Application no: 21/02177/DISC

Location: : Proposed Roundabout Access To Graven Hill And Wretchwick Green, London Road, Bicester

Local Lead Flood Authority

Objection

**B. Quick Storage Estimate**

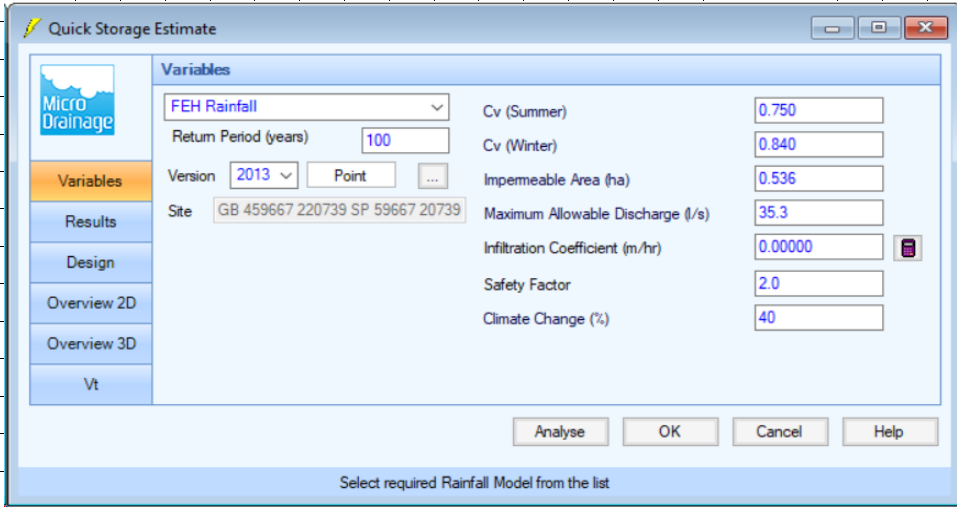
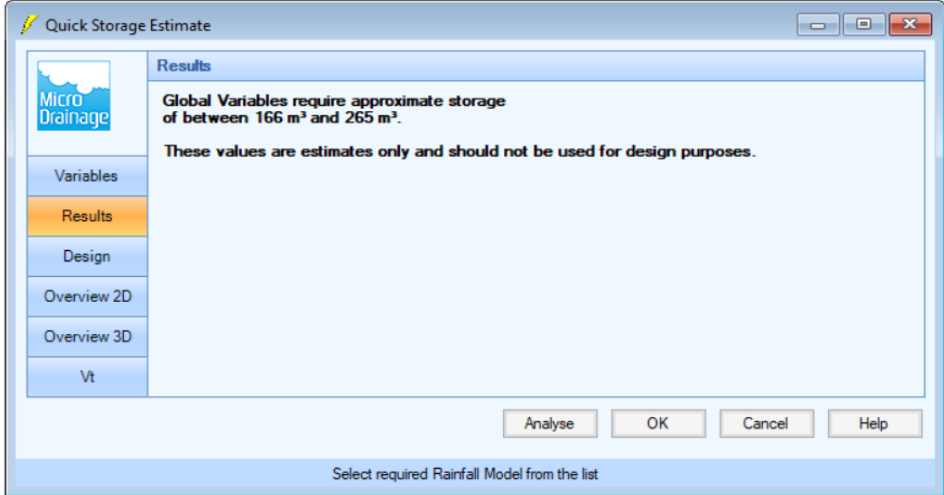
Calculation for rates are showing incorrect values.

Point 4.5 states “discharge rate of 35.4 l/sec (58.8x0.6)”. However, it should be 35.28 l/sec. Therefore, the actual reduction in discharge rate does not comply with our guidance of minimum 40% reduction/betterment in rates.

DRAINAGE STRATEGY PLAN

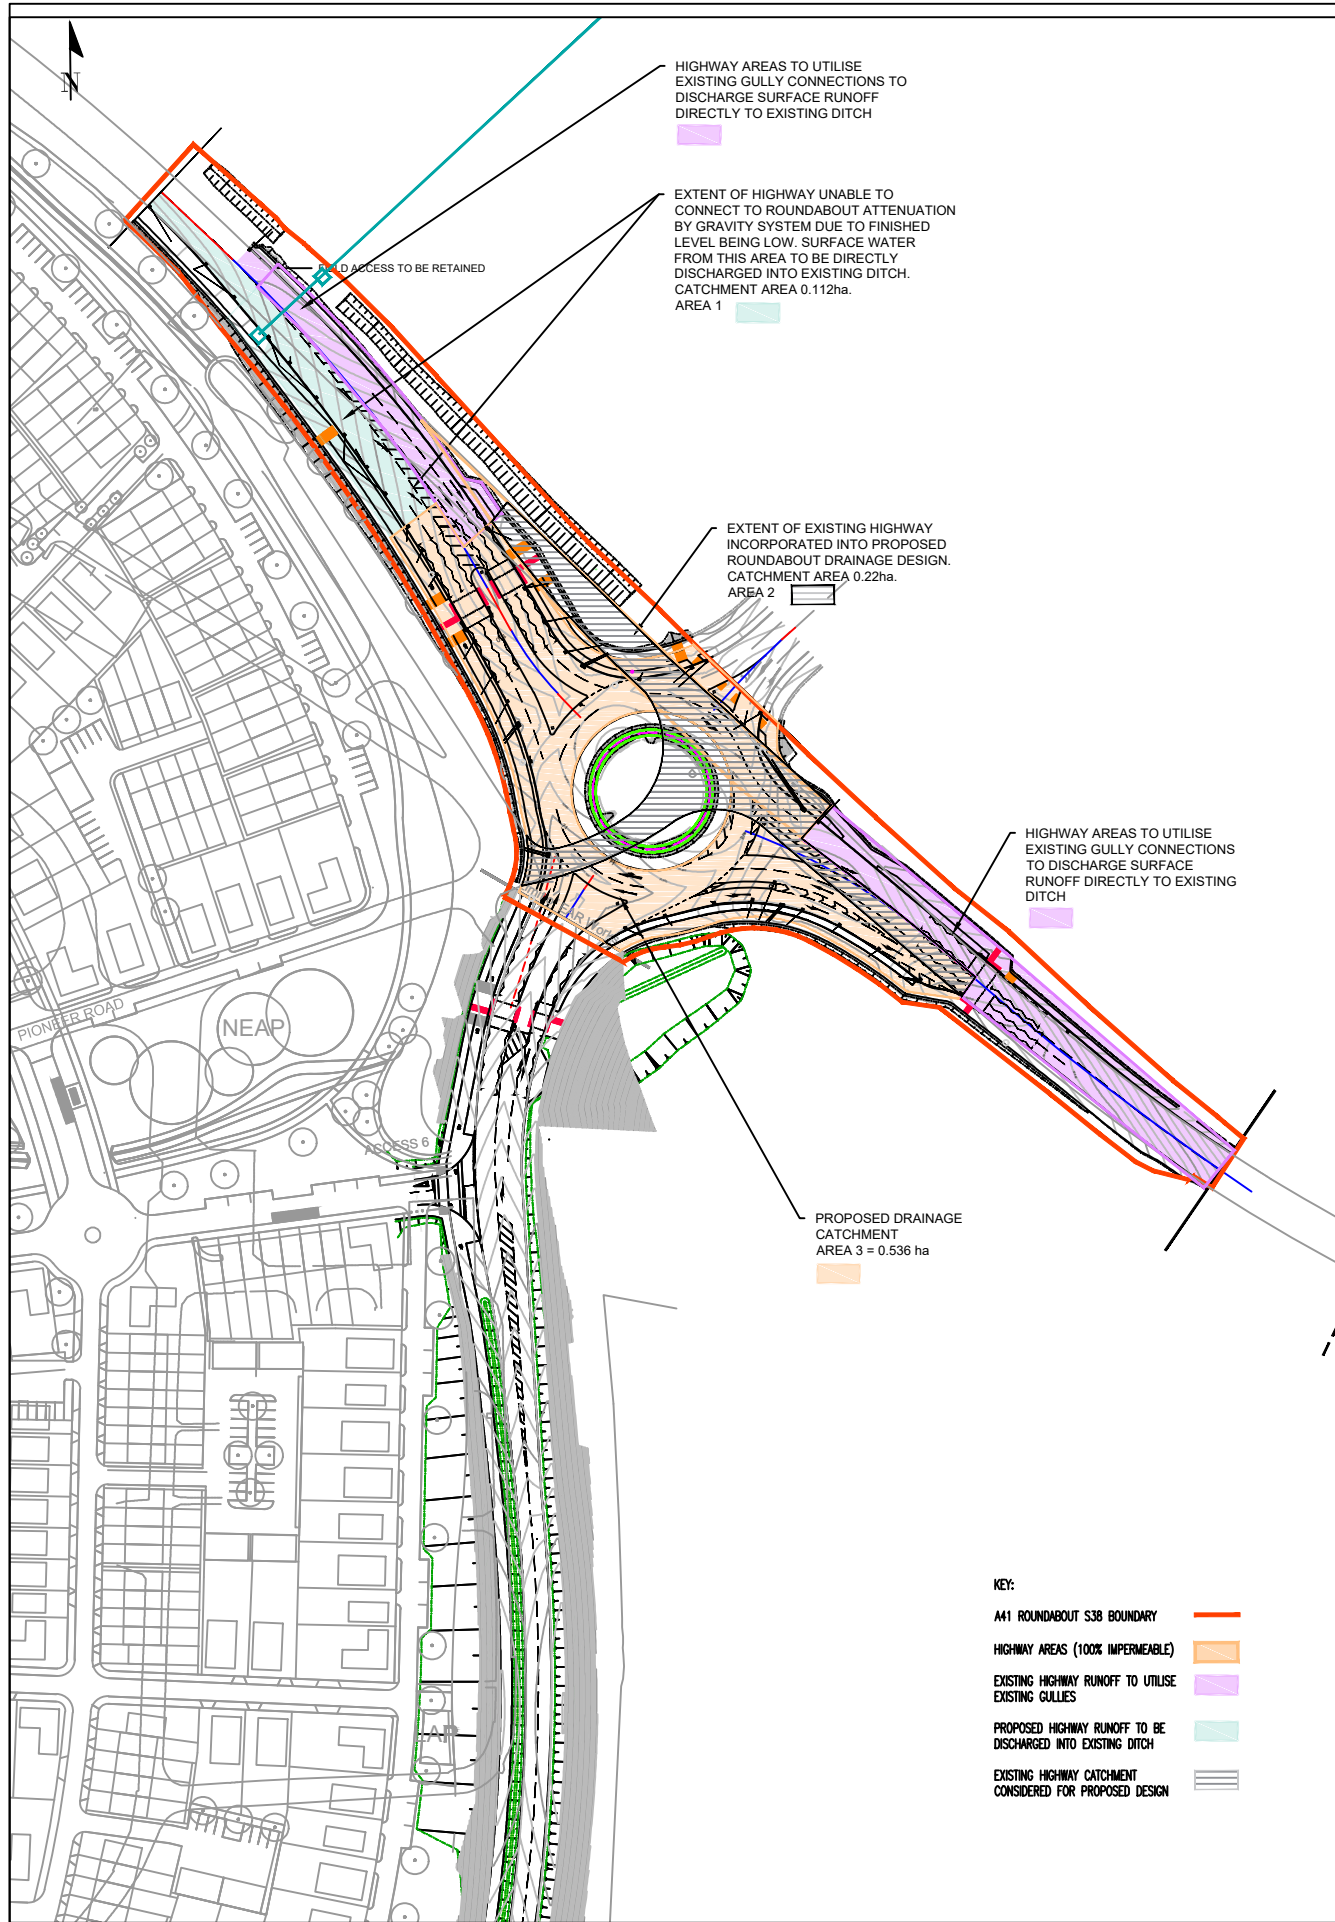
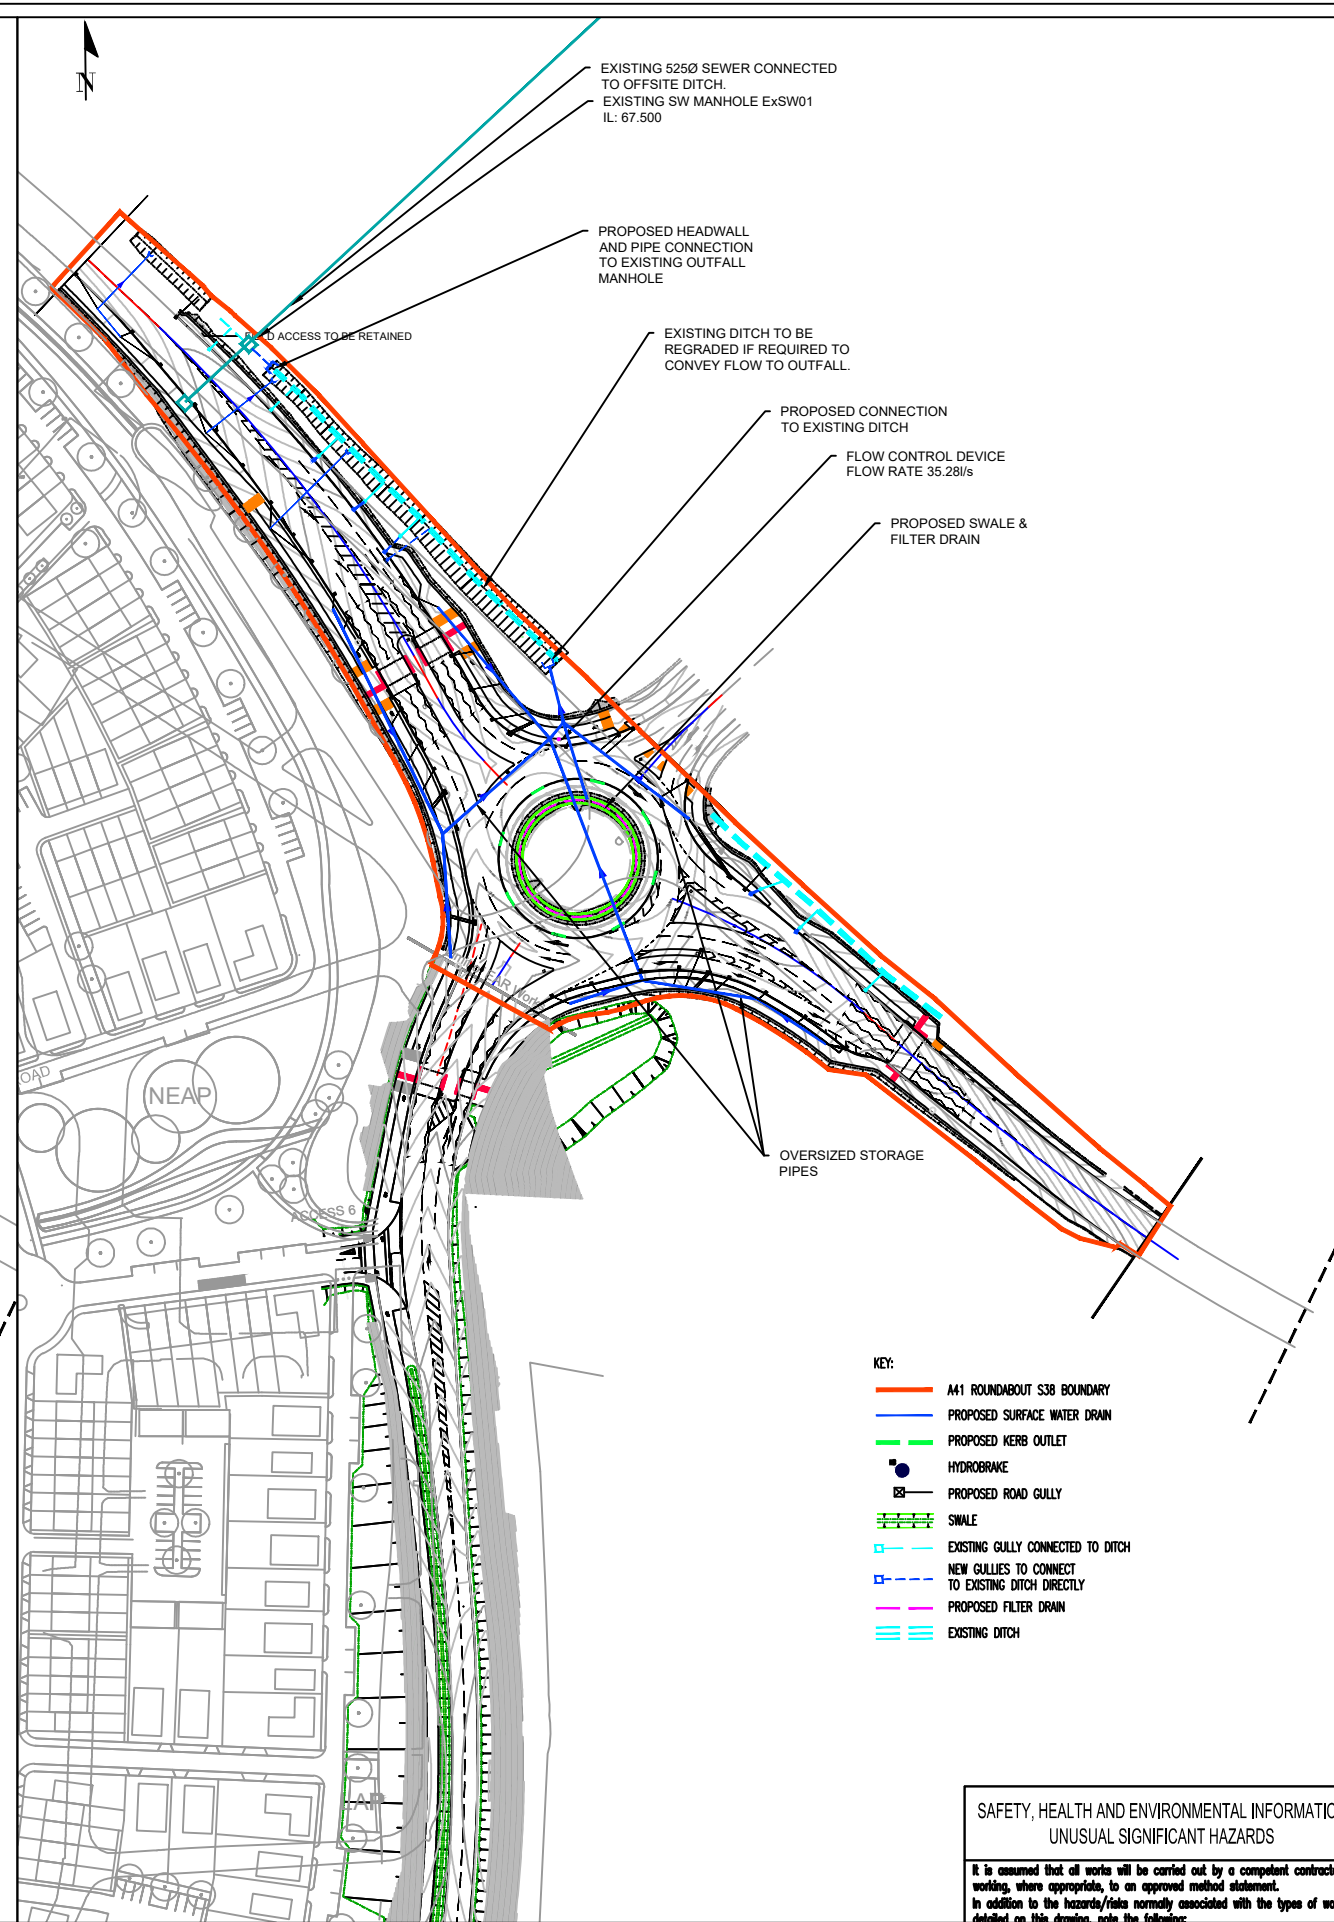
Water quality assessment must be carried out as there’s change in impermeable area across the development.

In addition, the data/strategy submitted must be in line with our guidance, including calculations.

A detailed surface water management strategy must be submitted in accordance with the [Local Standards and Guidance for Surface Water Drainage on Major Development in Oxfordshire](#)

In line with this guidance, runoff must be managed at source (i.e. close to where it falls) with residual flows then conveyed downstream to further storage or treatment components, where required. The proposed drainage should mimic the existing drainage regime of the site as much as possible.
